**Re: The Place @ Nob Hill, 3339 Central NE,
(K-16/D069)
Approval of Permanent Certificate of Occupancy,
Engineer's Stamp Dated: 08-30-07
Engineer's Certification Date: 4-09-09**

Based upon the information provided on 4/09/09, the above referenced certification is approved for release of Permanent Certificate of Occupancy by Hydrology.

**Re: The Place in Nob Hill, Central & Tulane
Grading and Drainage Plan
Engineer's Stamp dated 8-30-07 (K16/D69)**

Re: The Place @ Nob Hill, Monte Vista Addition on Central Ave NE
Grading and Drainage Plan
Engineer's Stamp dated 12-22-05 (K16-D69)

A111
OF

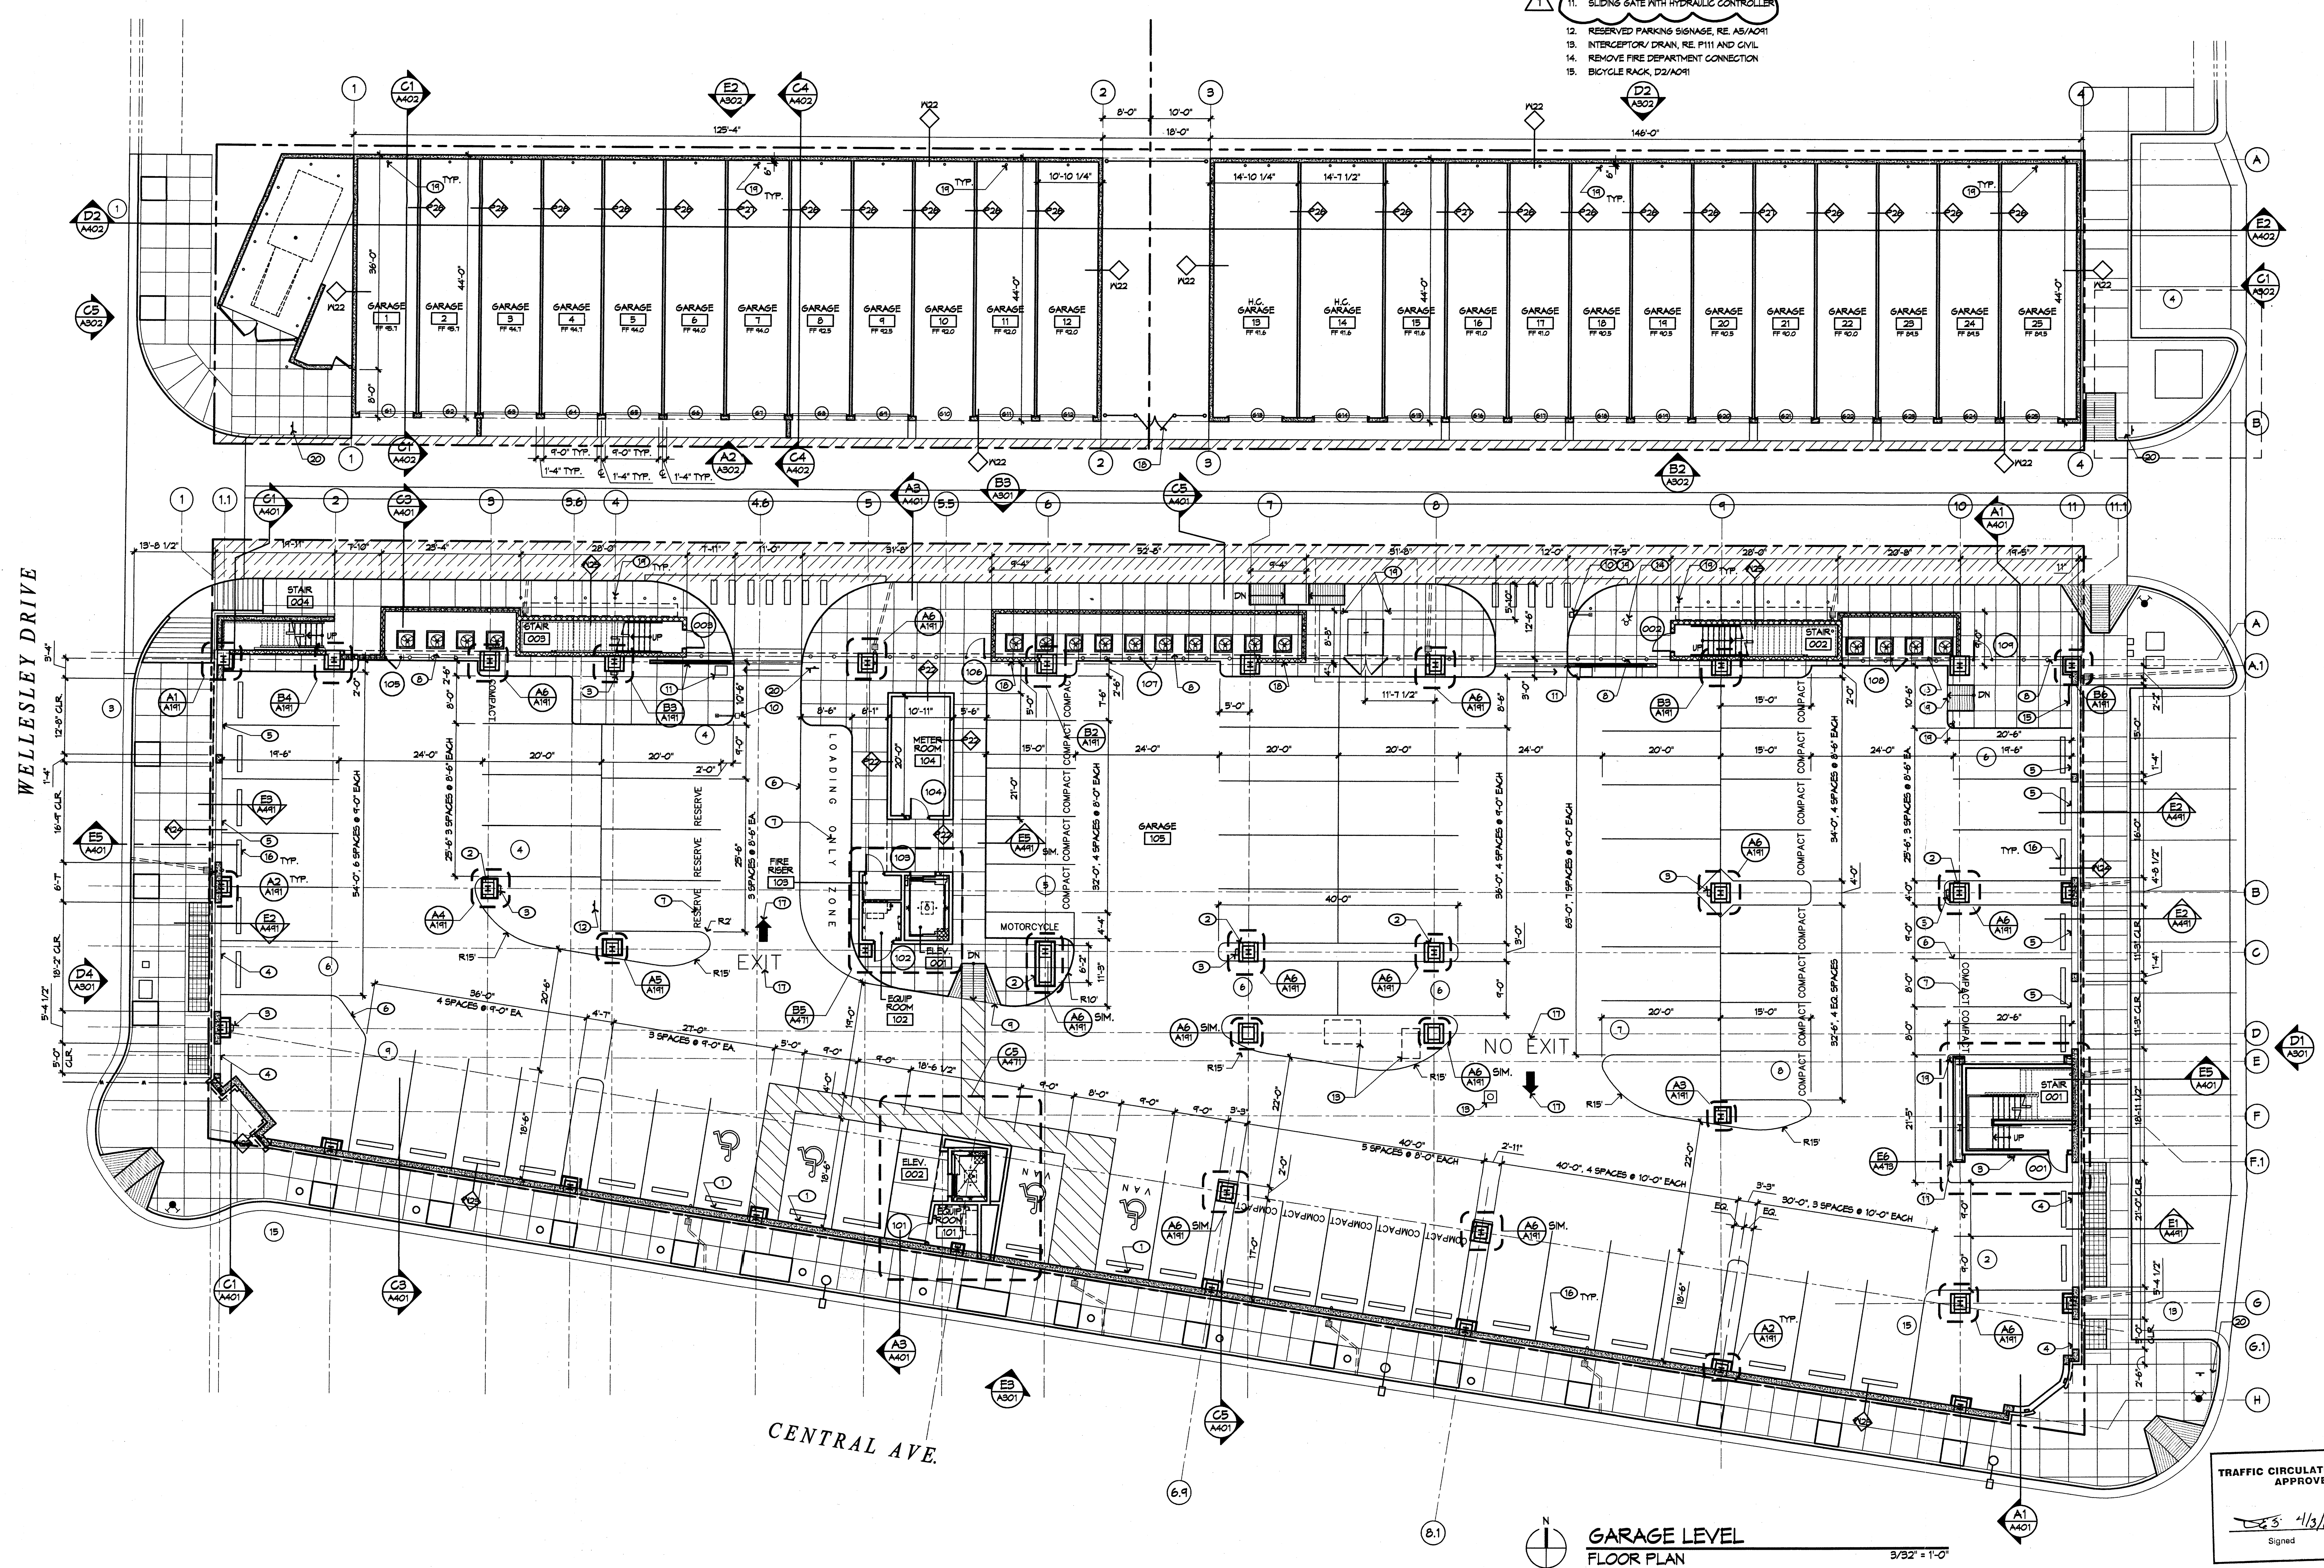
1. Provide parking calculations.
2. Include a vicinity map.
3. Please, refer to all appropriate City Standards; the drawing number should be included in this reference.
4. Dimension all parking stalls.
5. Why is the corner of Central and Wellesley belled out as indicated on the plan?
6. Traffic operation approval is required for note #18, speed bumps, and note #19, the cross walks.
7. Ensure that 18' parking stall is permissible with zoning.
8. The sidewalk along Tulane needs to meet ADA requirements.

SHEET NO.
C001

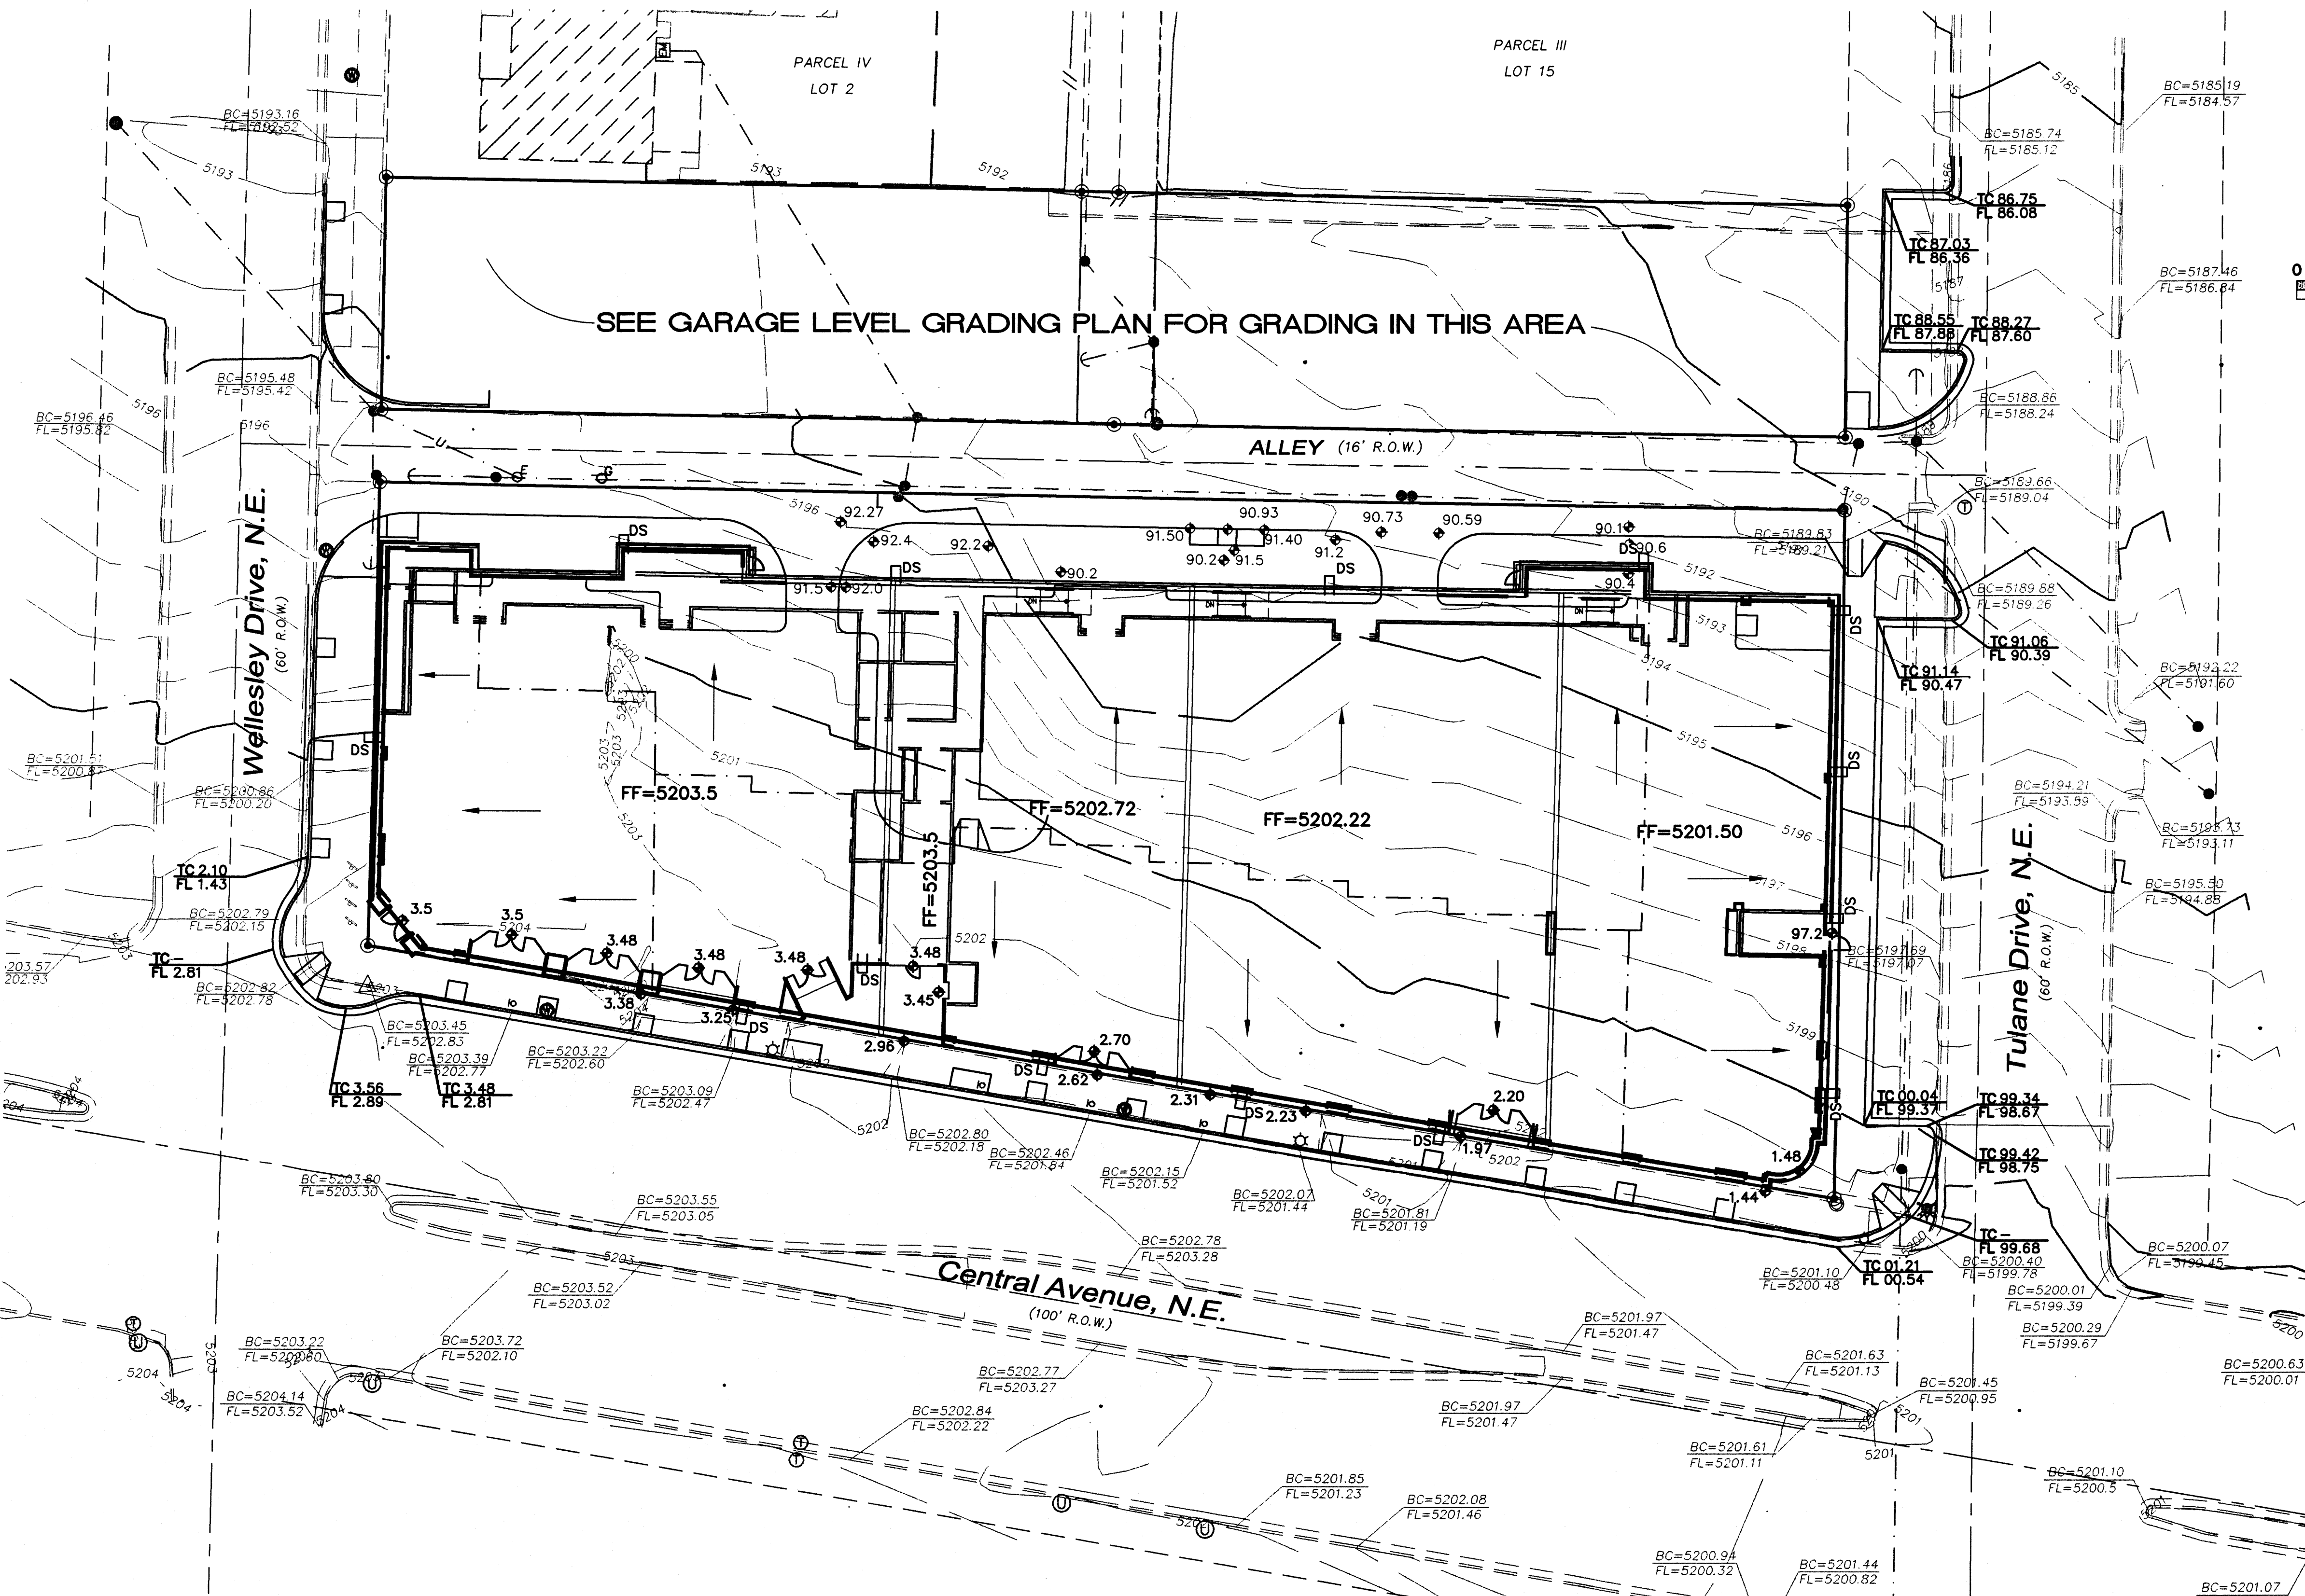
1. On the garages, show that the roof drains to the alleyway.
2. Sidewalk culverts are needed at all down spout locations and built according to COA Specs. This should be included in your Work Order drawings.
